16th November 2021
Our Ref: DW/E2100/161121

Planning Application 21/01224/OUT

Cherwell Local Plan Policy ESD10, National Policy as conveyed by NPPF 180 and statutory requirements of the Environment Act 2021

Response to note submitted by Ecology Solutions

Figure 1. Plan from CPA report identifying the survey area (red line) and key invertebrate (blue line)

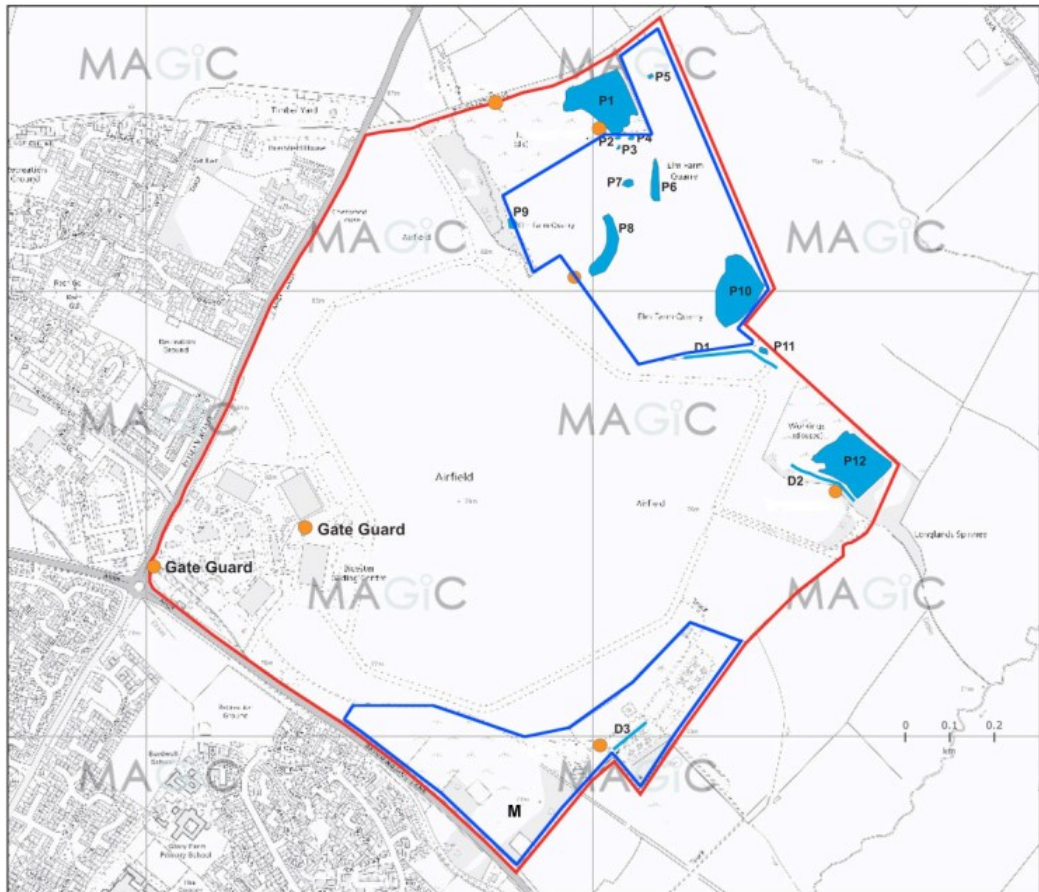
Paras 36 and 37 of the Ecology Solutions note suggest that the value of the habitats within the application site is lower than certain areas outside it, and refer to a plan produced by Colin Plant Associates showing a particular focus of invertebrate interest in the southern margin of the airfield. They fail to remark upon the fact that this ‘key invertebrate area’ is itself threatened by the F.A.S.T proposals (ref 19/02708/OUT). If that area is to be lost, the relative importance of the habitats within the current Application Site is undoubtedly raised. This is another example of the suspect, silo-based thinking that appears to pervade the consideration of biodiversity impacts on this site.
